From: Amanda Scholes on behalf of Planning.Responses
Sent: 15 December 2021 08:05
To: Planning Scanning
Subject: FW: Planning Consultation on: P/155/21/RES

Engineers Comments Regarding Surface Water Drainage

Application No: P/155/21/RES

Registered: 15th November 2021
Site Address: Land West of Pagham Road Pagham
Grid Reference: 488924 98195
Description of Works: Approval of reserved matters (layout, scale, appearance and landscaping) following outline consent P/140/16/OUT for the 'local centre' parcel which comprises of retail, community and commercial uses, 20 No residential apartments and a 70 bed care home.

Drawing Title:
Tree Protection Plan

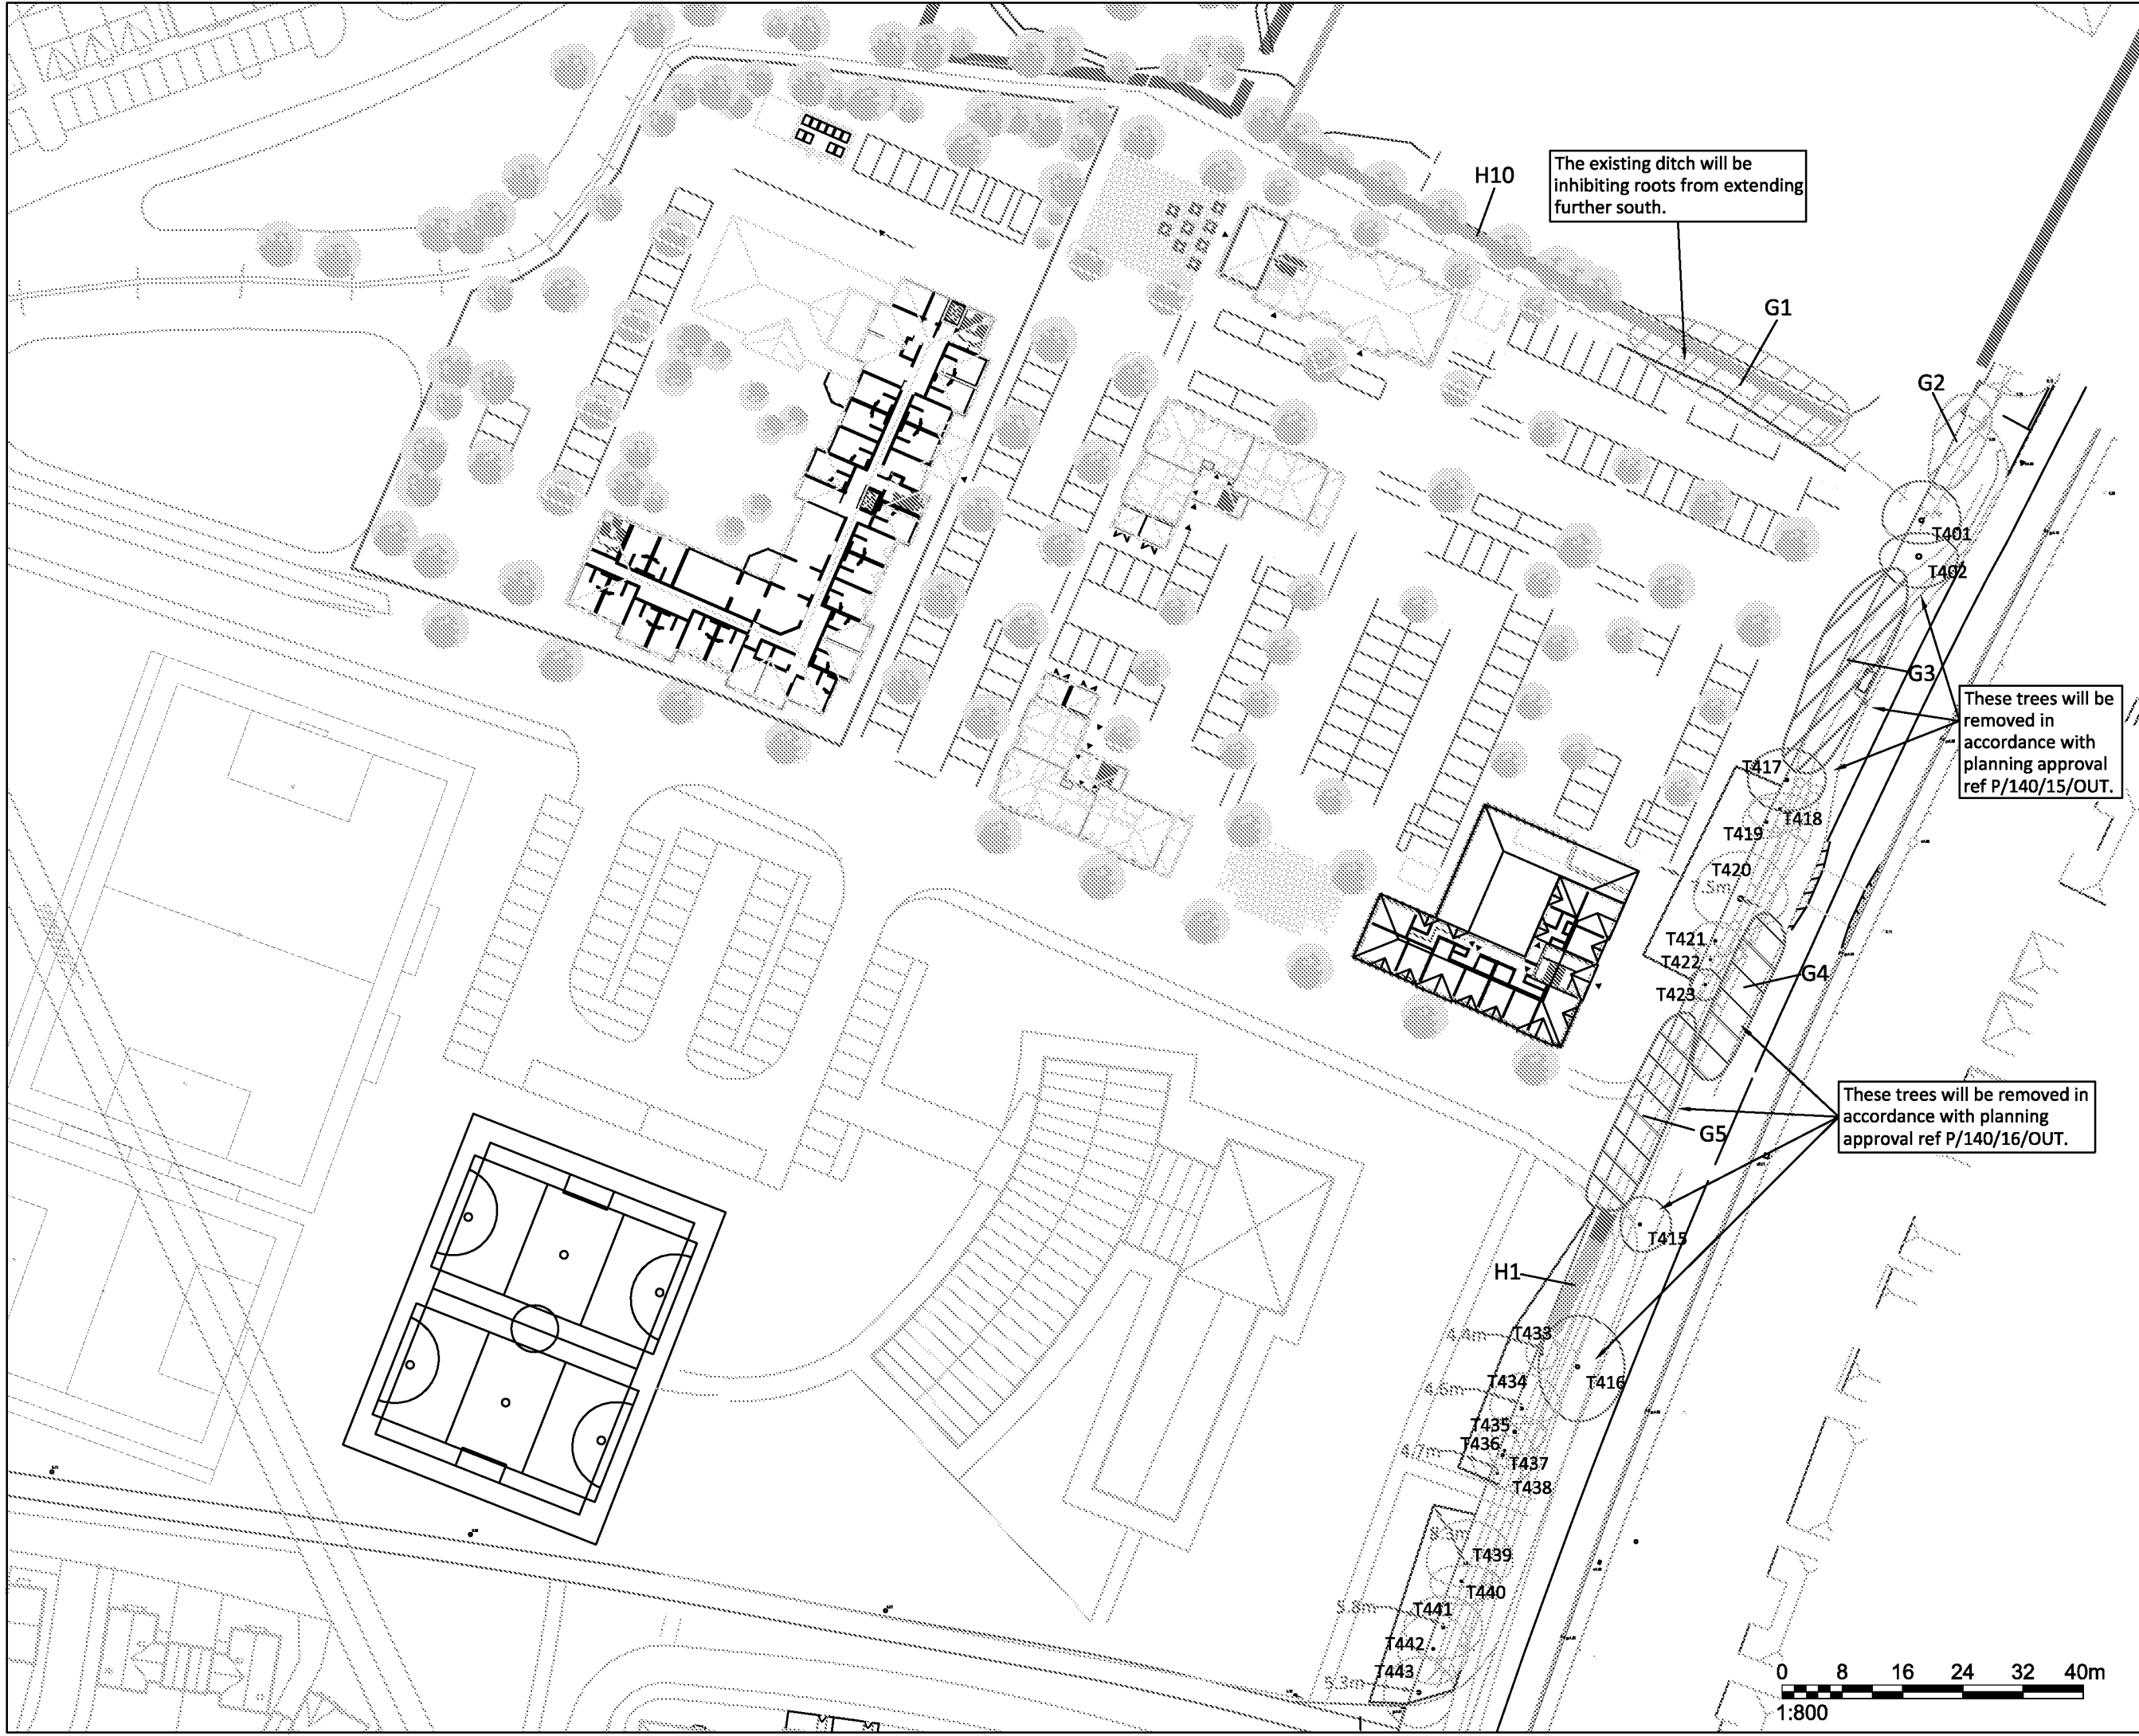
3. FEH2013 rainfall data must be applied to calculations.
4. Surcharged outfalls should be applied to calculations. The surcharged outfall levels should be set to adjacent top of bank level.
5. A minimum of two perpendicular cross sections per basin must be supplied.
6. We note that a number of trees are proposed in close proximity to drainage features. Root potential areas must not conflict with surface water drainage features.

PROPOSED DRAINAGE STRATEGY

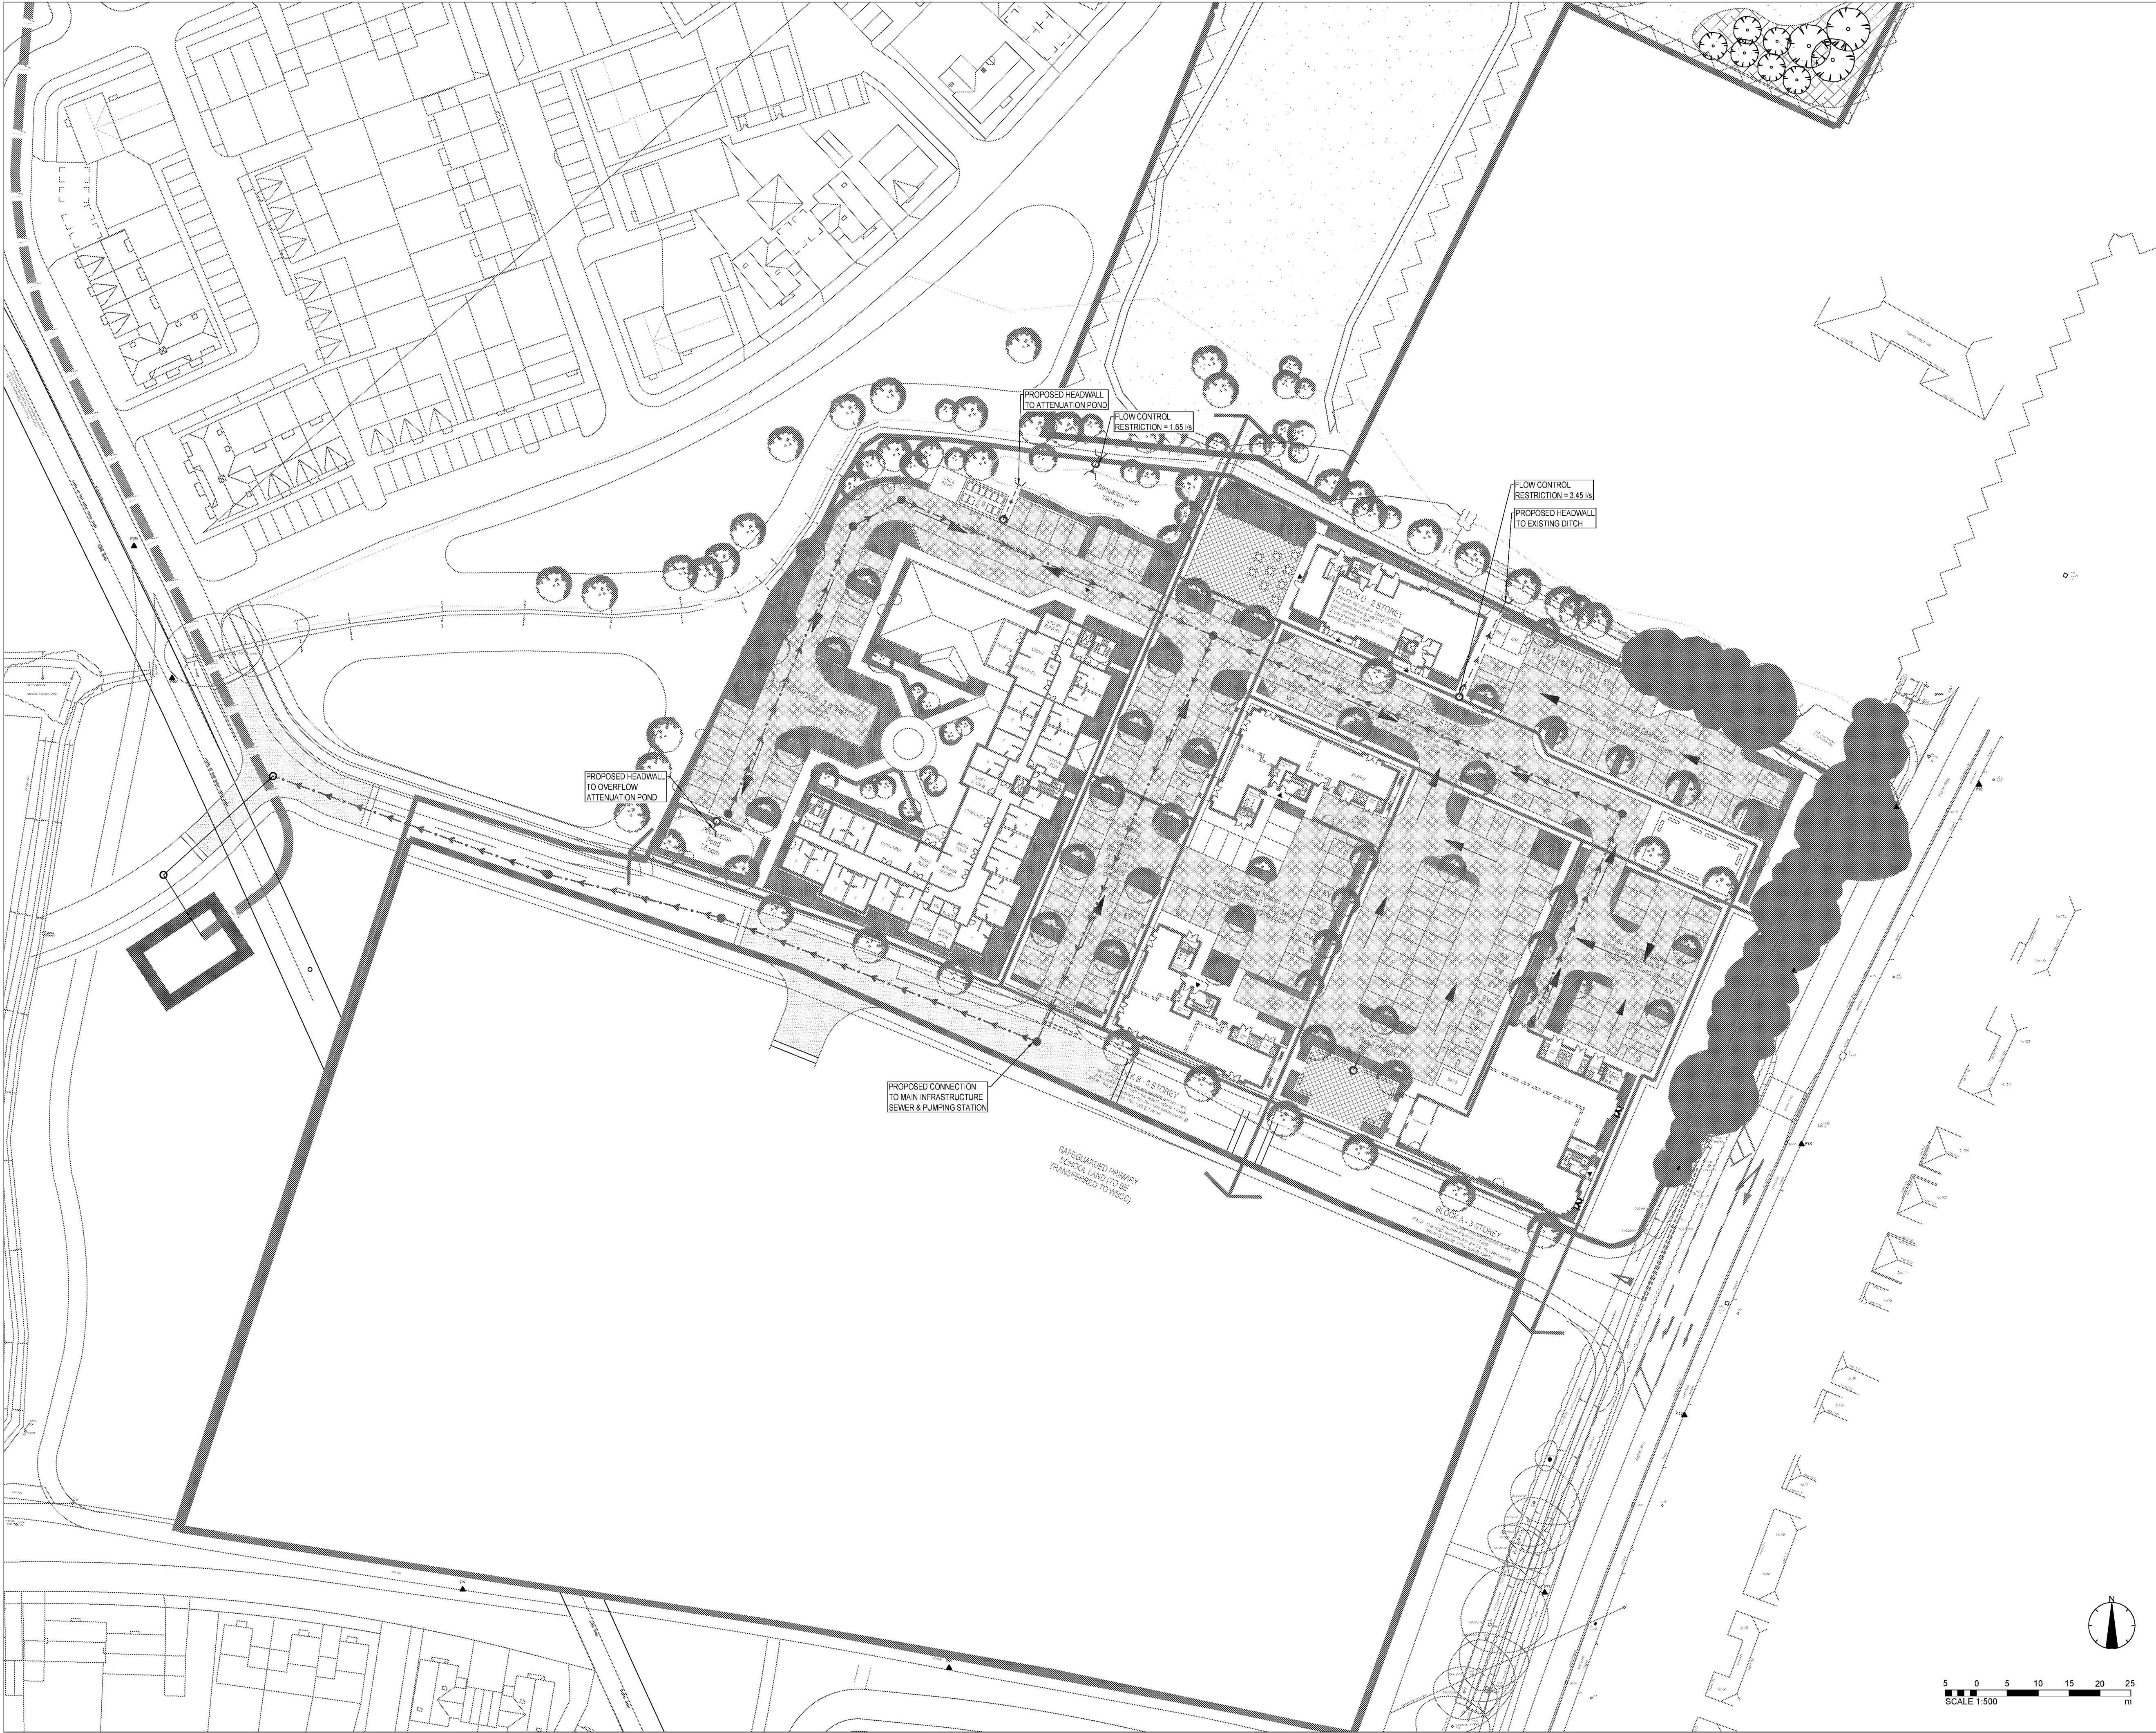
The proposed layout has a SuDS basin, buildings, trees, and fence lines proposed within very close proximity to the watercourses. All of these features must be at least 3m away from the top of bank of watercourse.

1. The proposed discharge rate is too high. The calculation of discharge rates should be based upon the positively drained area. Revised greenfield runoff rate calculations should be supplied.
2. Ordinary watercourse land drainage consent is required for all new outfalls and for proposed culverts.

We would also like to highlight that the a full winters groundwater monitoring will be required, even for an attenuation scheme. Peak groundwater level at attenuation features should be established and used in design to evidence that flotation is adequately accounted for in design.
